Our Ref: A/123/26/NMA

Non material amendment following the grant of A/88/24/S73 to swap in new house type range.

Land North of Water Lane Angmering

CLIENT:	Rydon Homes Ltd / Gleeson Land	PROJECT:	Land North of Water Lane Angmering
SCALE:	1:100 (A1 ORIGINAL)	DRAWING:	Plot 325 Proposed Plans and Elevations
DRAWN:	BH	19271	P286
DATE:	Jul '26		-

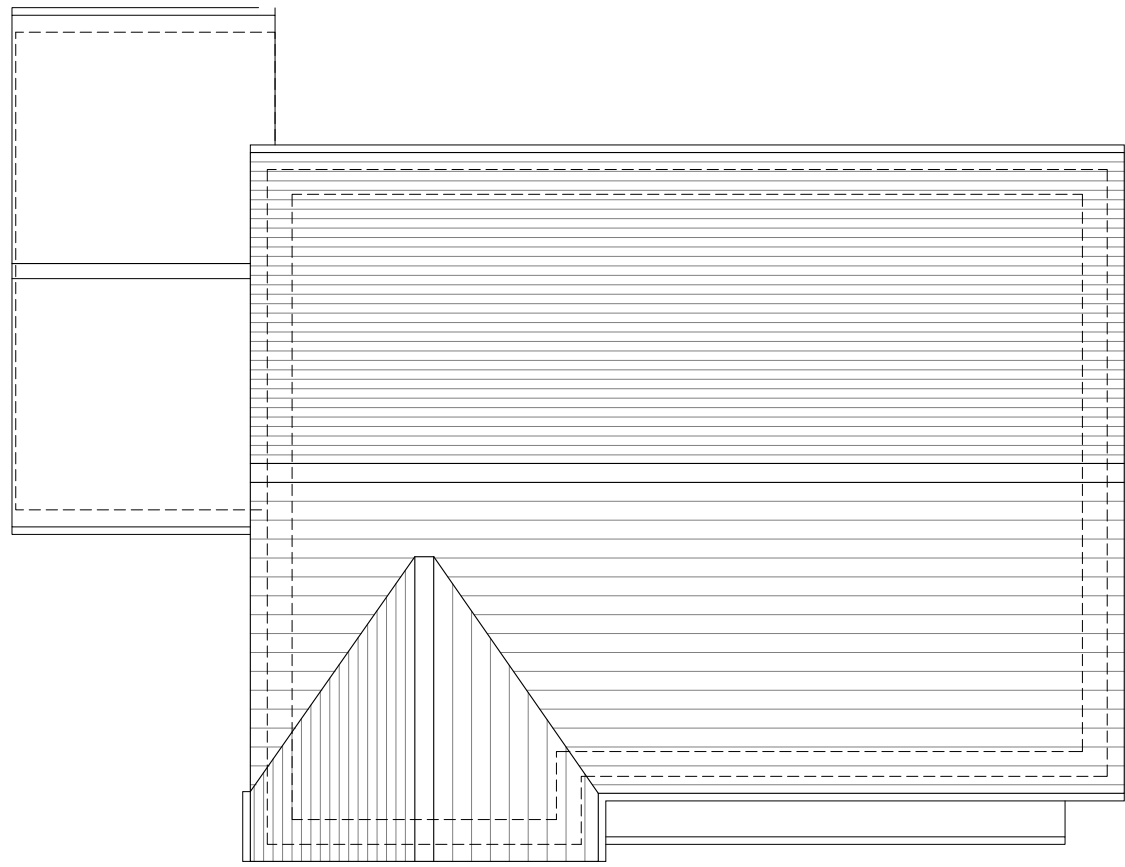
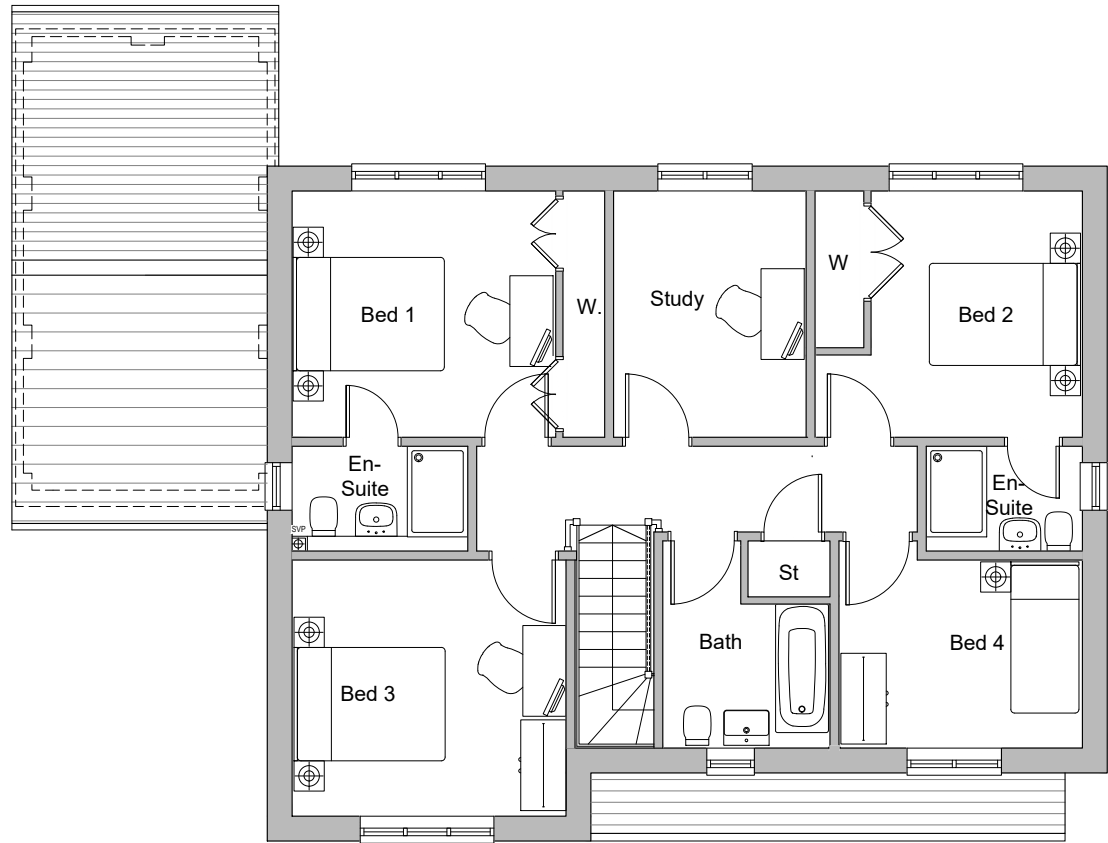
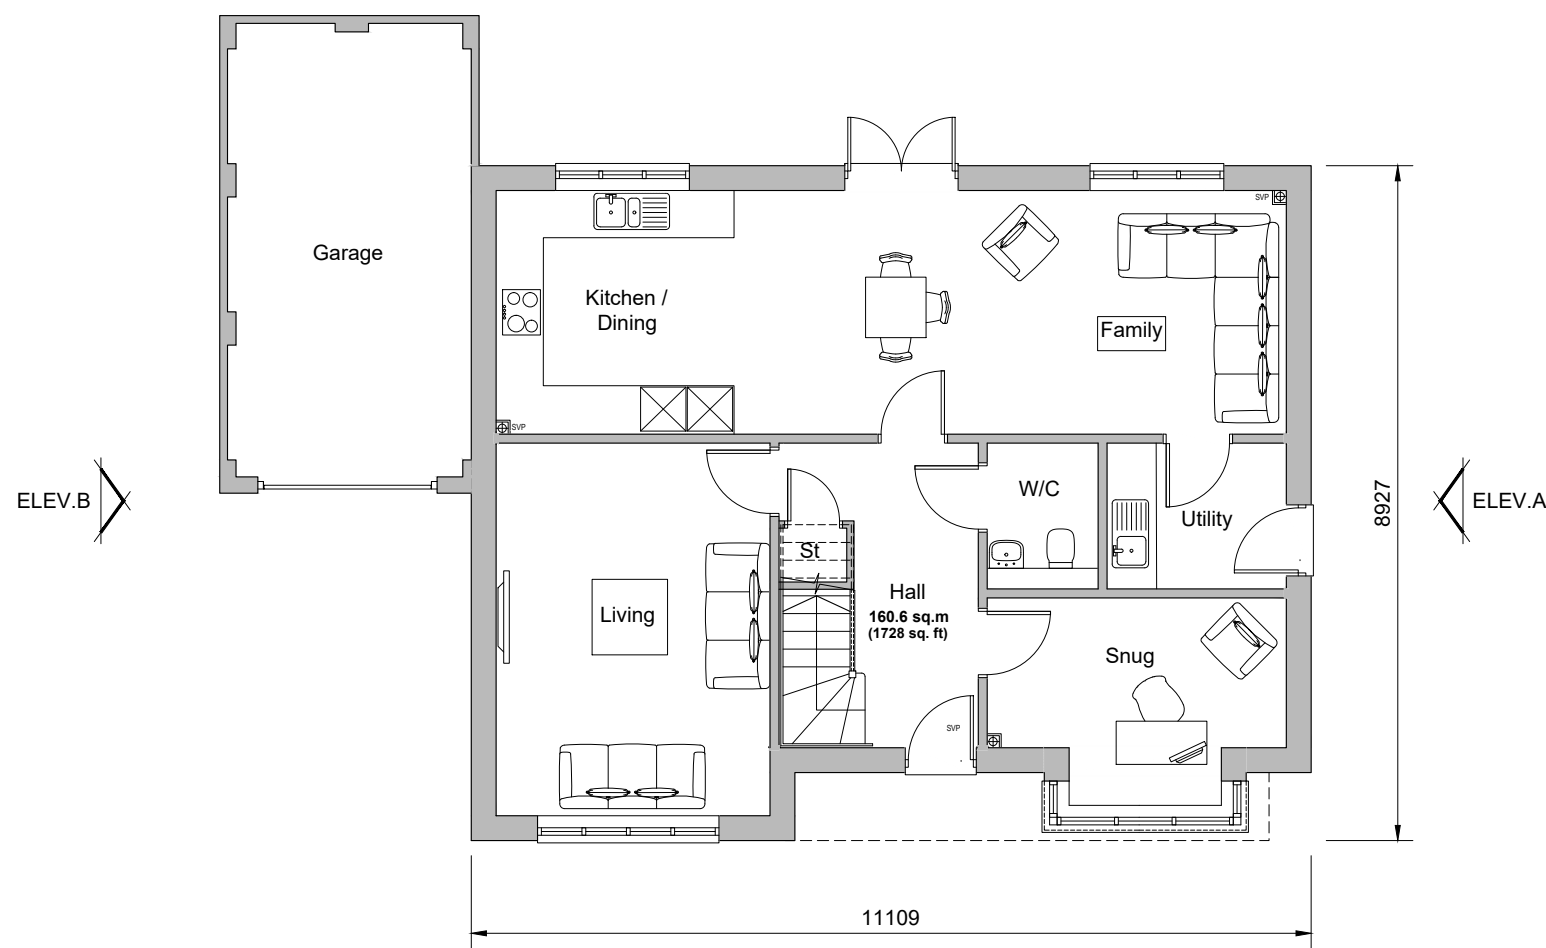
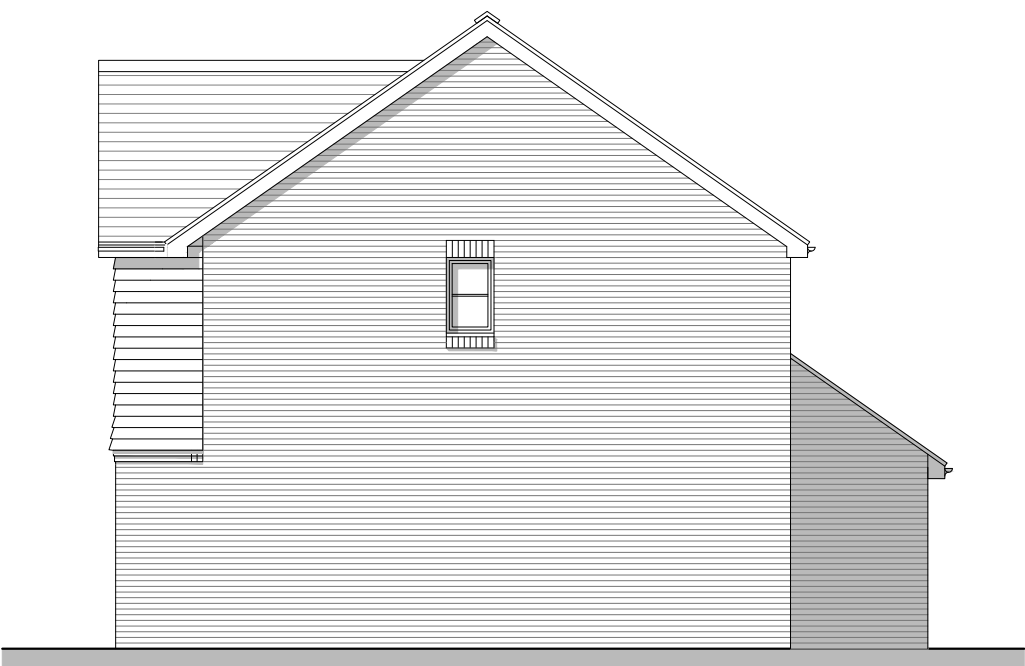
Walnut to New Walnut (10 plots): 293, 294, 295, 306, 309, 325, 327, 348, 349 and 350.

The amendments would result in minor alterations to the appearance and external materials of the affected dwellings. No changes are proposed to the number of bedrooms, building heights, or overall scale of the units. Furthermore, no additional habitable-room windows are proposed that would overlook neighbouring properties or result in any material loss of privacy.

P286 Plot 325 - Plans & Elevations (Dated July 2026)
